# EAST PRESTON PARISH COUNCIL

1<sup>st</sup> October 2012

Re: EP/40/12 – 115-117 Sea Road, East Preston

The Planning Committee of this council considered the two substitute plans submitted for this Application at its meeting on Monday, 24<sup>th</sup> September. The committee was disappointed that the substitute plans do not address any of the objections previously submitted, and therefore the committee agreed that it would continue to object to this Application on the grounds set out below.

Figure 10 - Window Orientation Detail

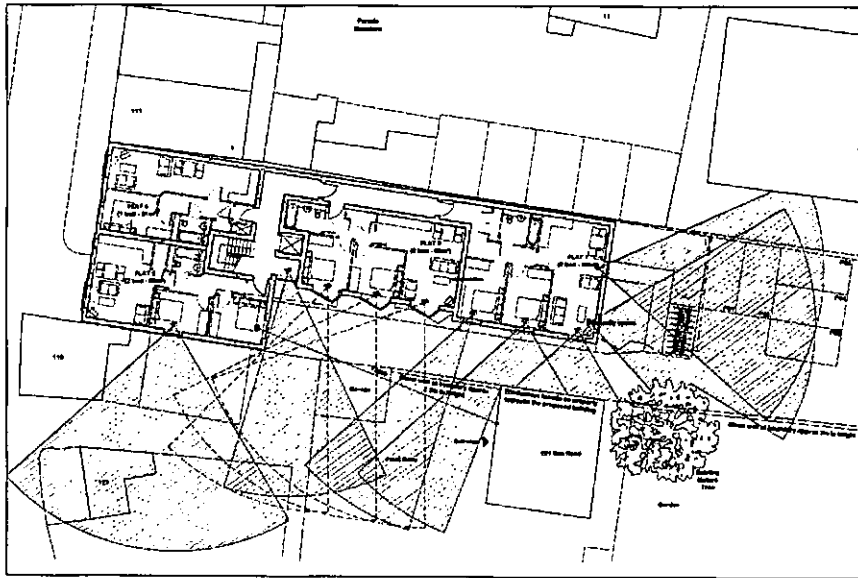
6. The plans with regards to the windows in Flats 2 and 6 are confusing. On the Indicative 3D Visuals drawing, south-east facing windows are clearly shown, but the impact of these windows is not shown on the Window Orientation Detail. These windows will be able to see into a number of windows on the western and northern elevations of 121 Sea Road, and that property's front garden.

drawing: Ground Floor Plan
scale: 1:200 @ A3 date: Dec '11

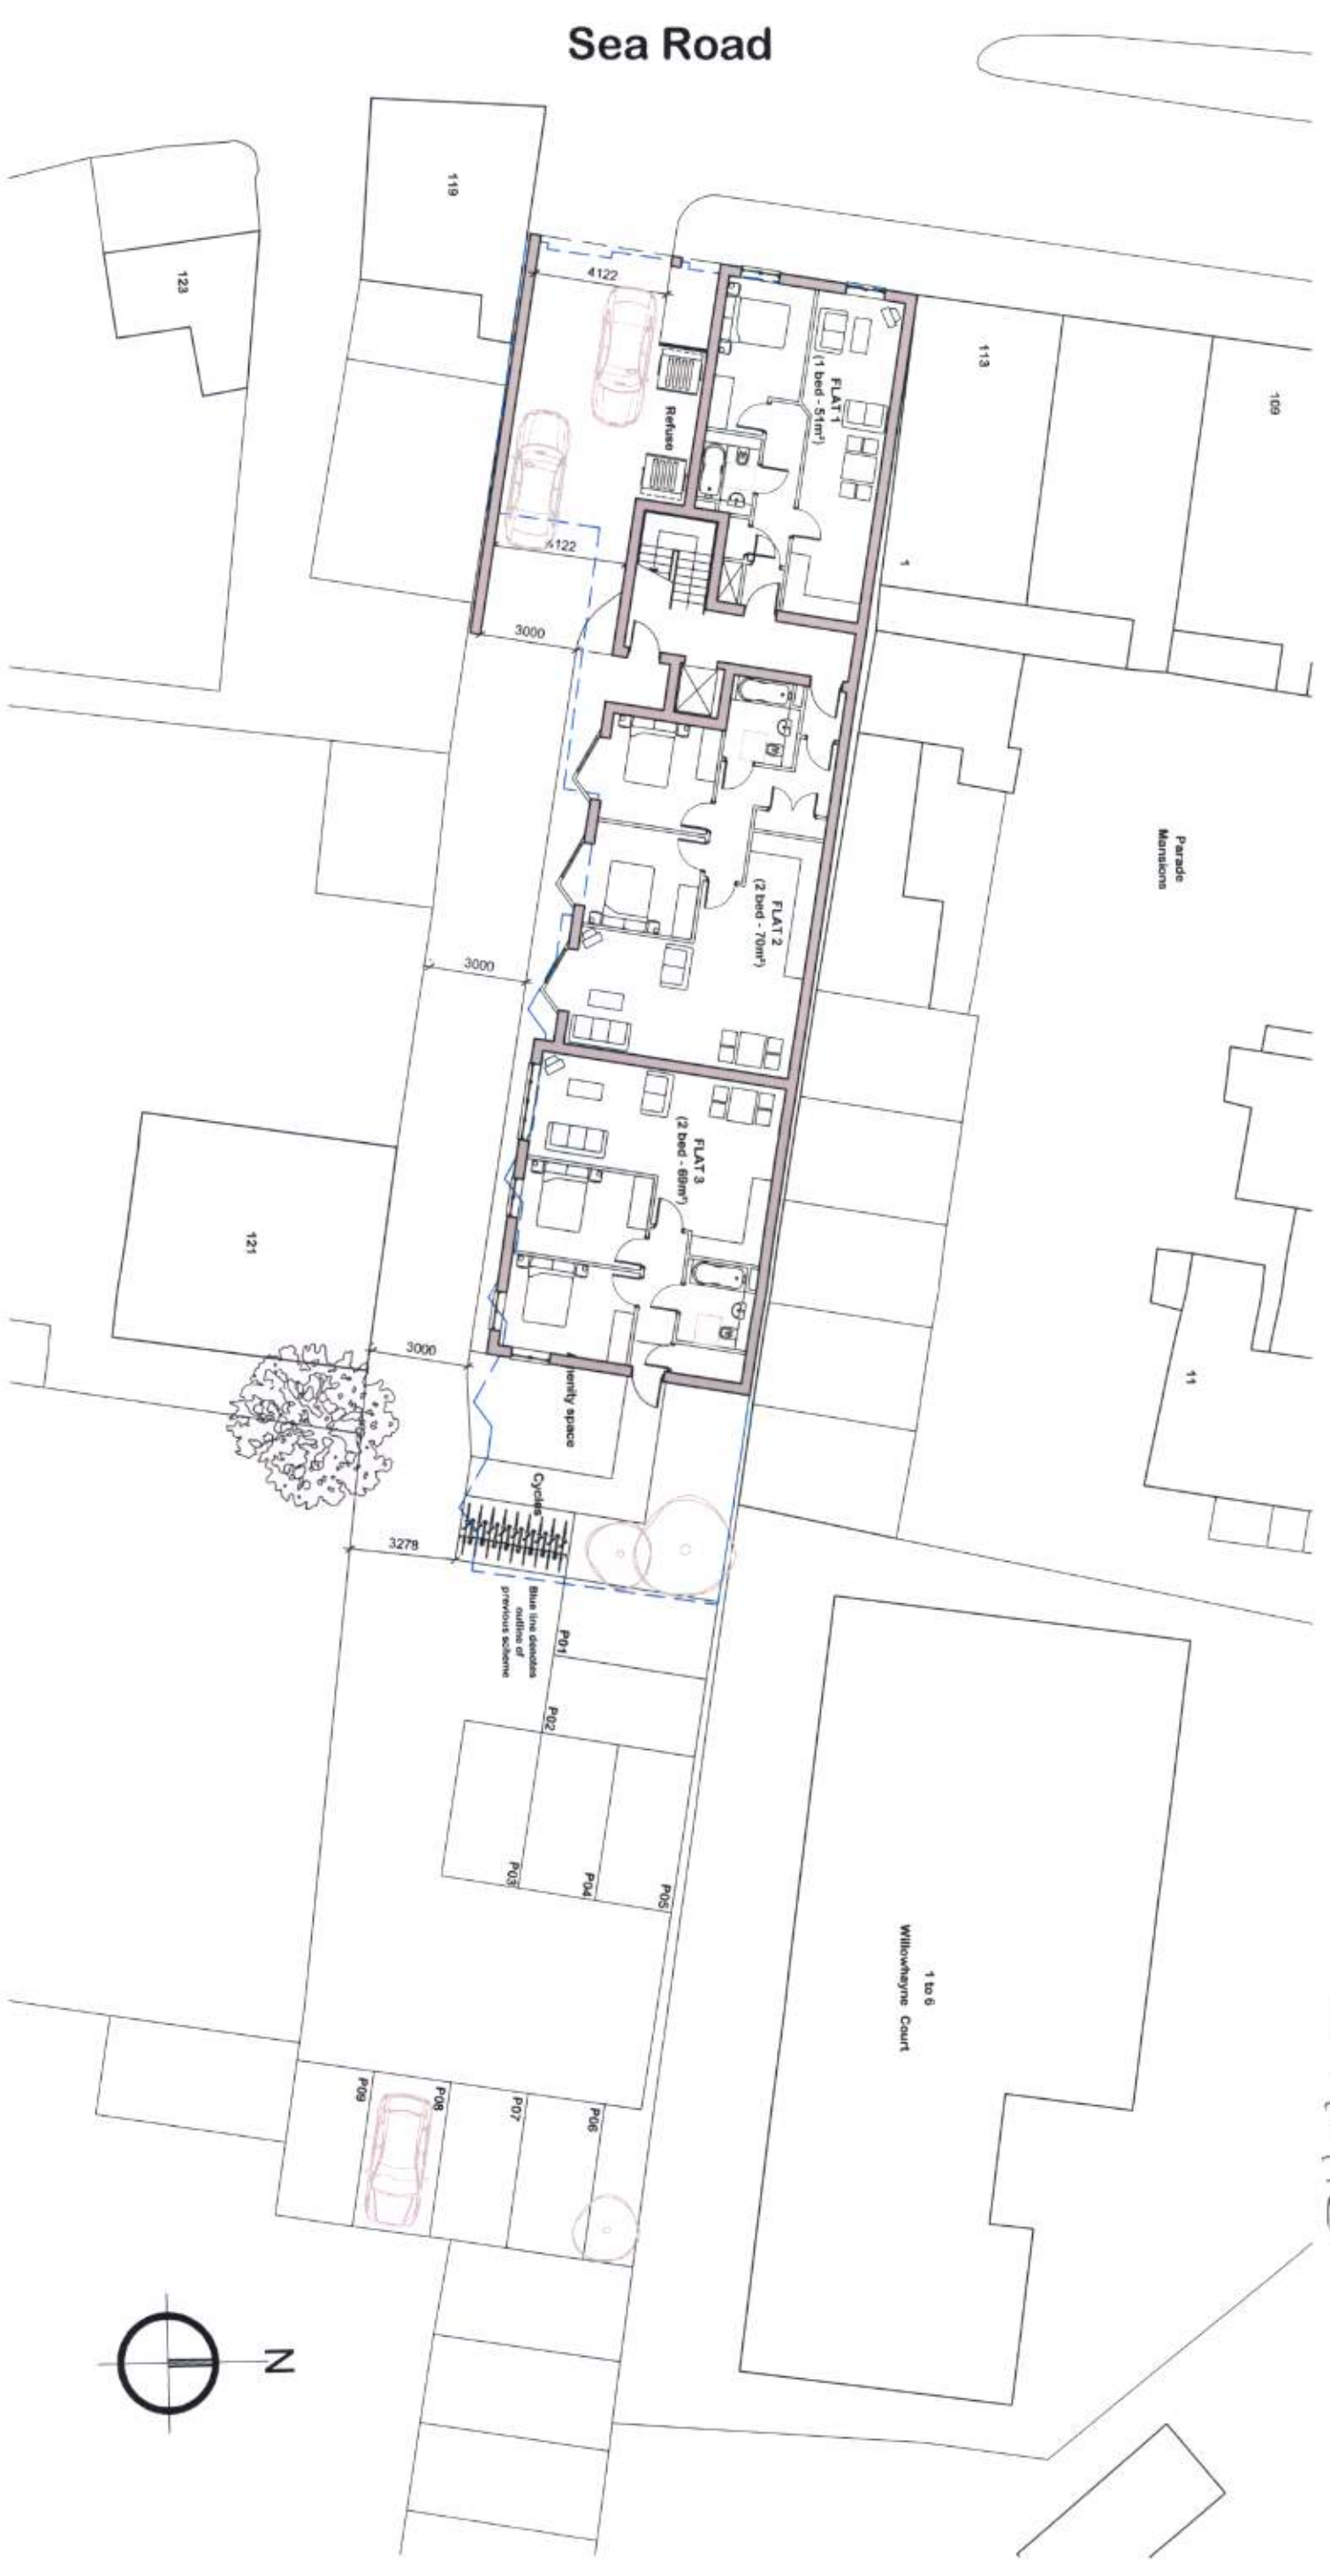
10. The proposal provides only nine parking spaces for a development totalling fifteen double bedrooms. Local on-street parking is at a premium, especially during the summer and at weekends. Reference is made to the nearby car-park, but that has already been used as a reason not to provide more on-site parking for the recently-completed Tamarisk Apartments development on the corner of Sea Road and Manor Road. The car-park does not have the capacity to handle overspill parking for another development.

11. This council is concerned also that pedestrian access to the building is through the undercroft with no pavement and no obvious demarcation between pedestrian walkway and vehicle access. Clearly two-way vehicular access/egress is only possible by the omission of a walkway or pavement - there are obvious safety implications here.

project: 115-117 Sea Road, East Preston
client: Oakhurst Developments Ltd
drawing: Roof Plan
scale: 1:200 @ A3 date: Dec '11

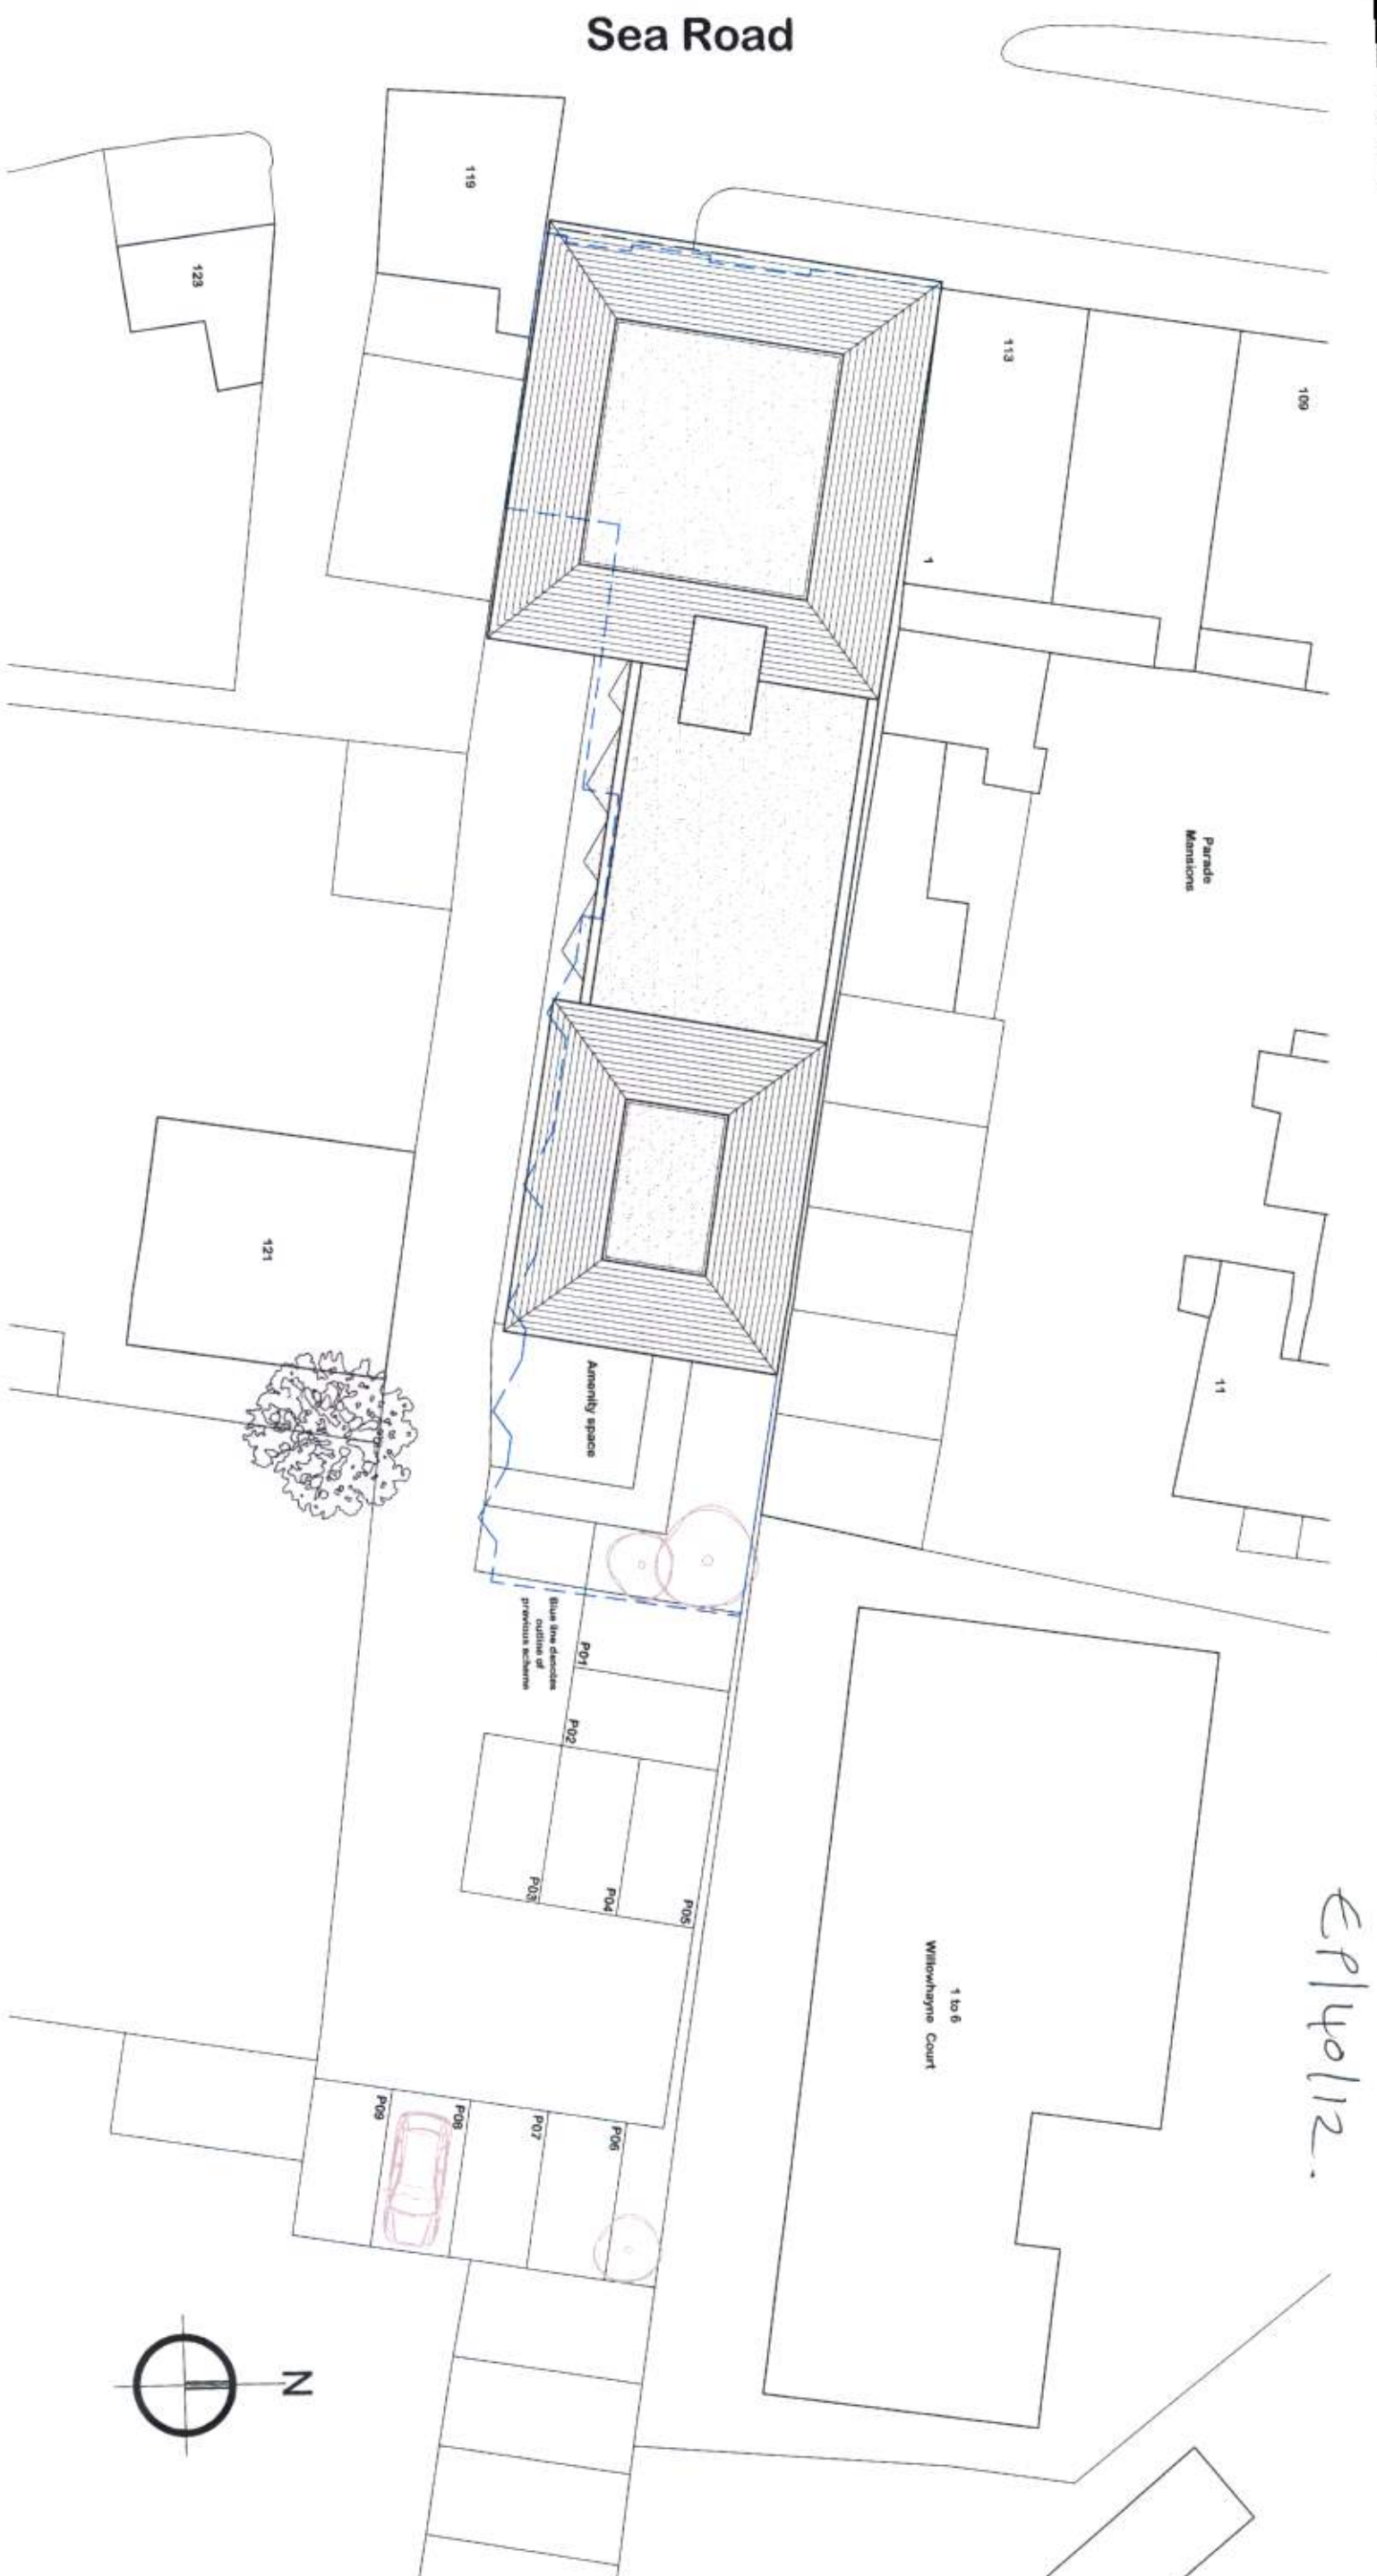
4. The proposed development would result in material detriment to the amenities of the occupiers of the neighbouring properties by reason of overshadowing, loss of natural sunlight and its oppressive and overbearing impact. Although not clearly shown on the plans, the roof terrace would also impact upon the enjoyment of neighbouring property owners with the additional concern of noise pollution. The proposal would thereby detract from the amenities and quiet enjoyment of these properties in conflict with Saved Policy GEN7 of the Arun District Local Plan.

number: 3279/P201 rev: D  
dm: agw chkd: ge appd: ge

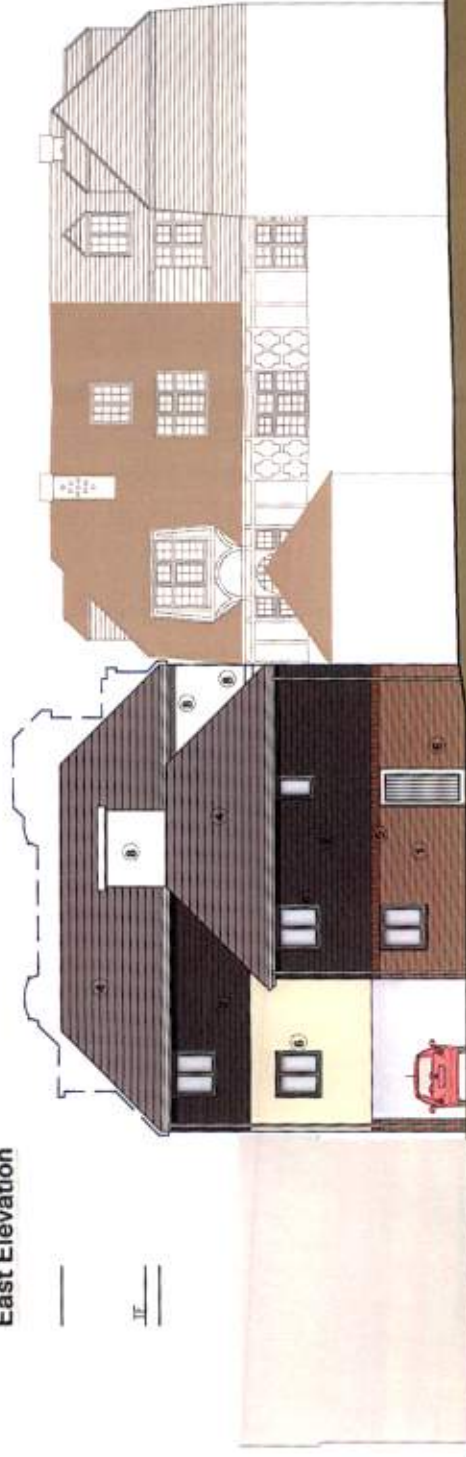
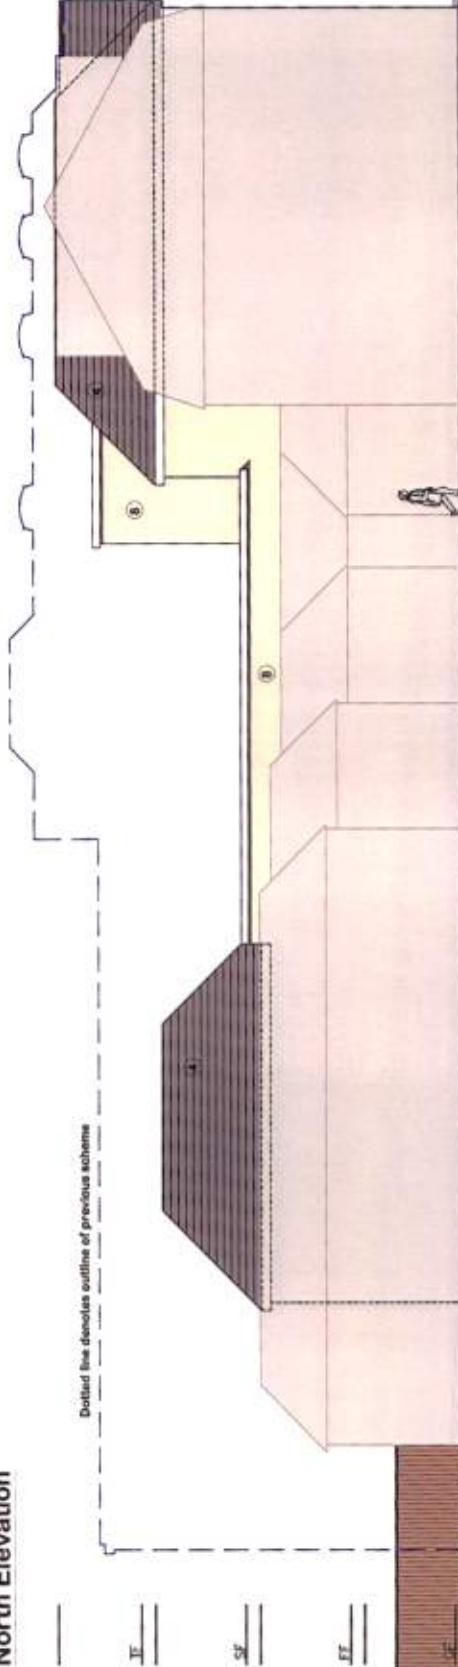
3. The design of the building is inappropriate for its immediate surroundings and does not harmonise with the existing traditional buildings in this parade of shops and the residential accommodation above. Parade Mansions in East Preston's southern shopping area is located in an area of special sensitivity that deserves protection from unsympathetic development. The proposal is therefore contrary to the provisions of the East Preston Village Design Statement (pages 8 and 15 refer). The fact that the existing 115-117 Sea Road are not in keeping must be no reason for the proposed design to be out of keeping too, and the National Planning Policy Framework allows Planning Authorities to refuse

8. The proposed contemporary design and materials would have an unacceptable adverse impact on the adjoining existing Parade Mansions buildings which would adversely affect the street scene, contrary to Saved Policy GEN7 of the Local Plan and to the provisions of the East Preston Village Design Statement.
